CELBRIDGE HAZELHATCH MOBILITY CORRIDOR

Responses to Submissions on Section 177AE Consent Application

MDT0902-RPS-00-XX-SH-Z-1001

11th February 2026

C01

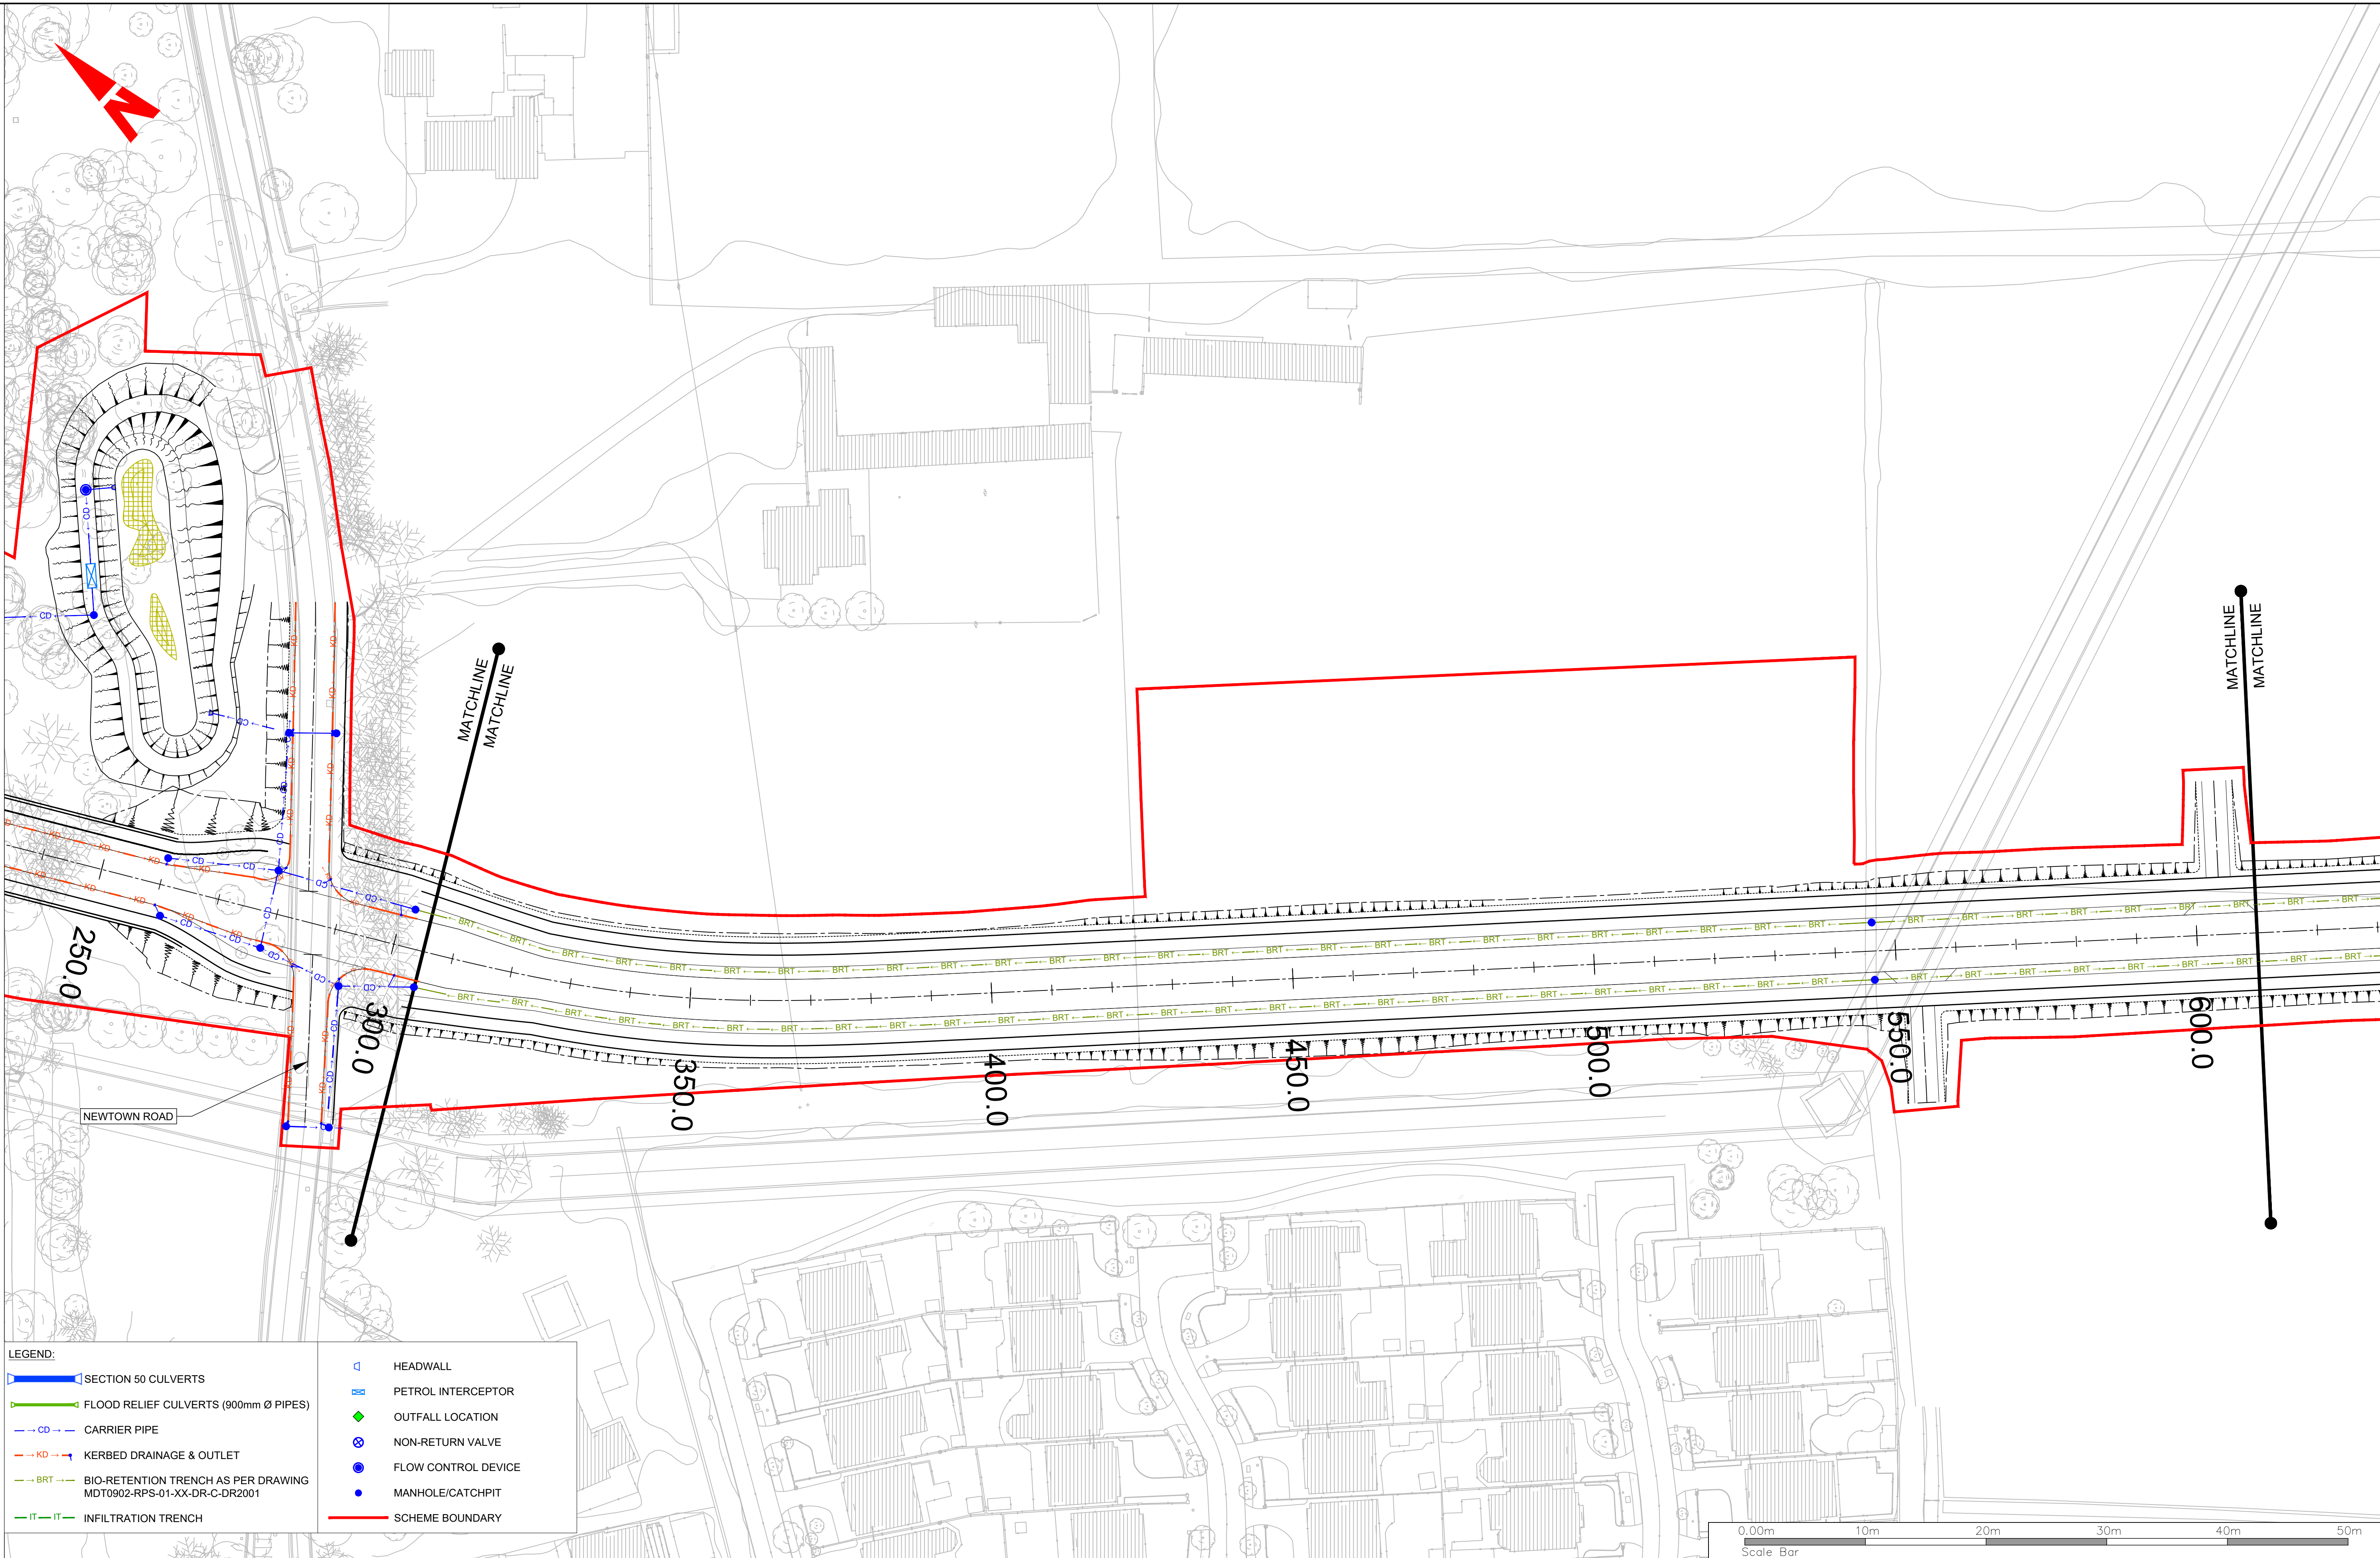
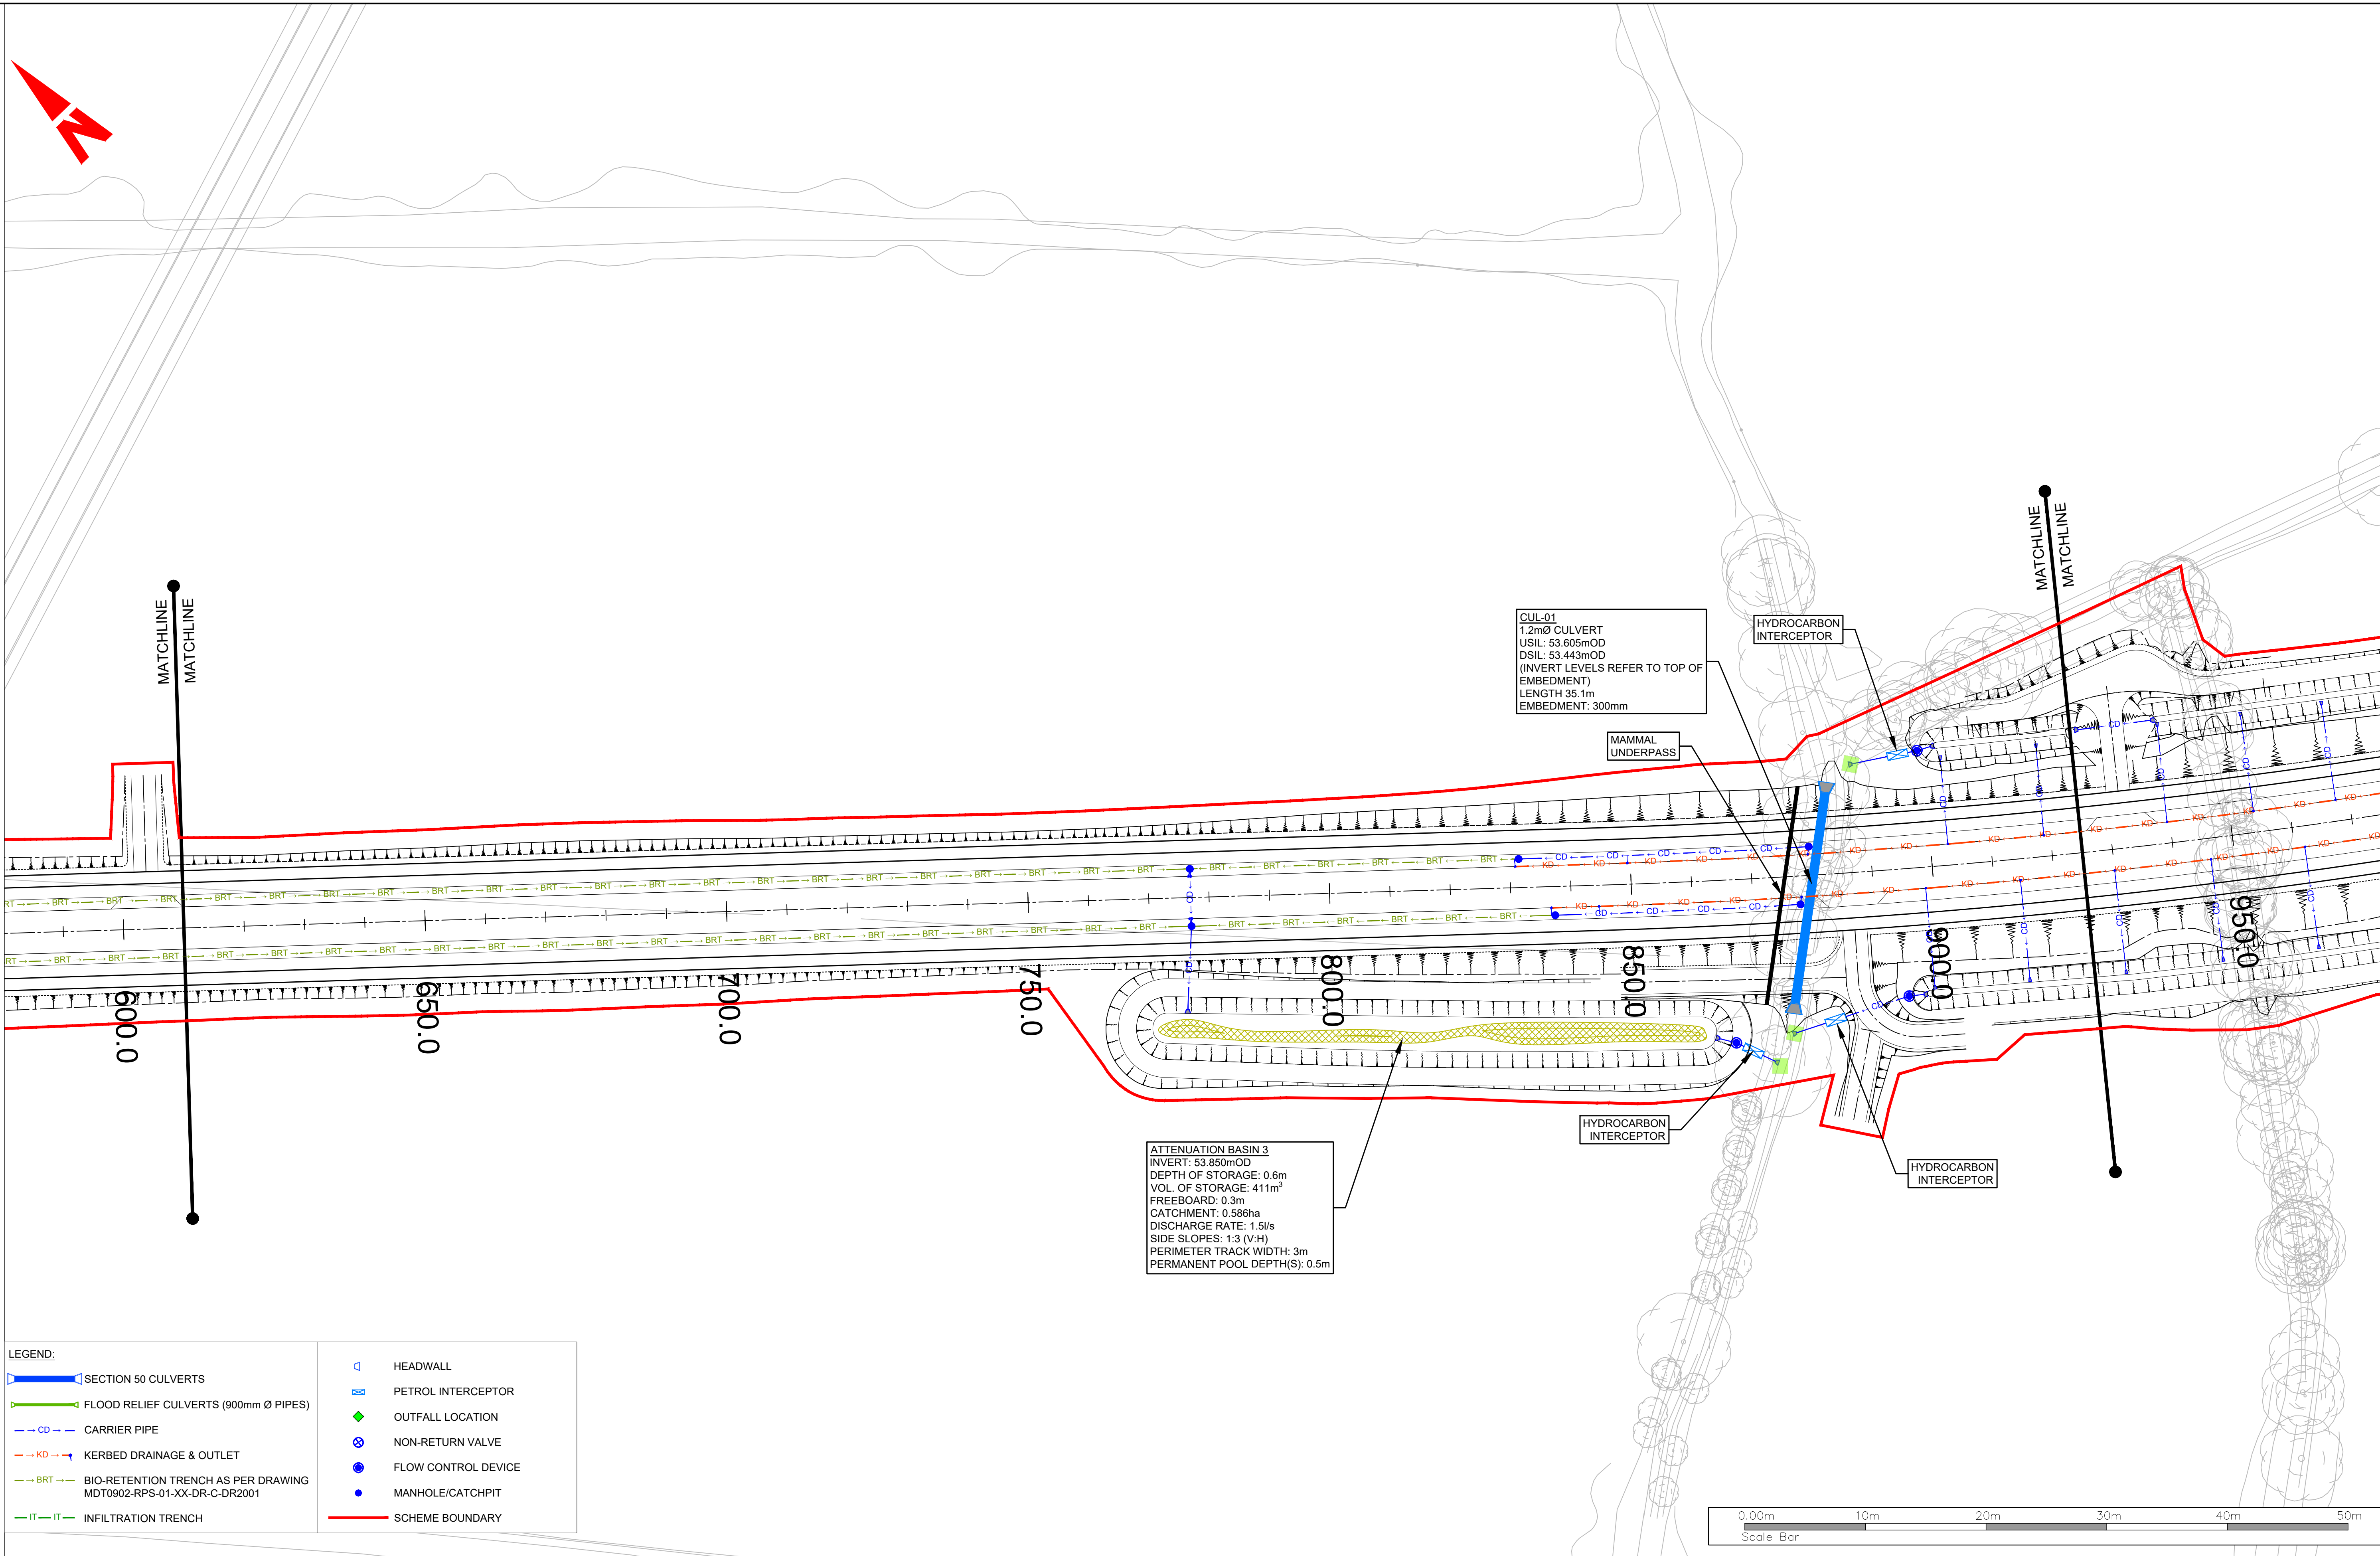
12.	All discharges must follow the European Communities (Surface Water) Regulations 2009 and the European Communities (Groundwater) Regulations 2010.	The proposed surface water drainage layout for the proposed development is illustrated on drawings MDT0902-RPS-01-XX-DR-C-DR0000-DR0007. Various SuDS features are incorporated into the design of the proposed development to reduce operational phase pollutant run-off into watercourses and pollutant infiltration into groundwater in accordance with the European Communities (Surface Water) Regulations 2009 and the European Communities (Groundwater) Regulations 2010 and approval is sought on this basis and subject to such further Conditions as may be imposed by the Competent Authority.
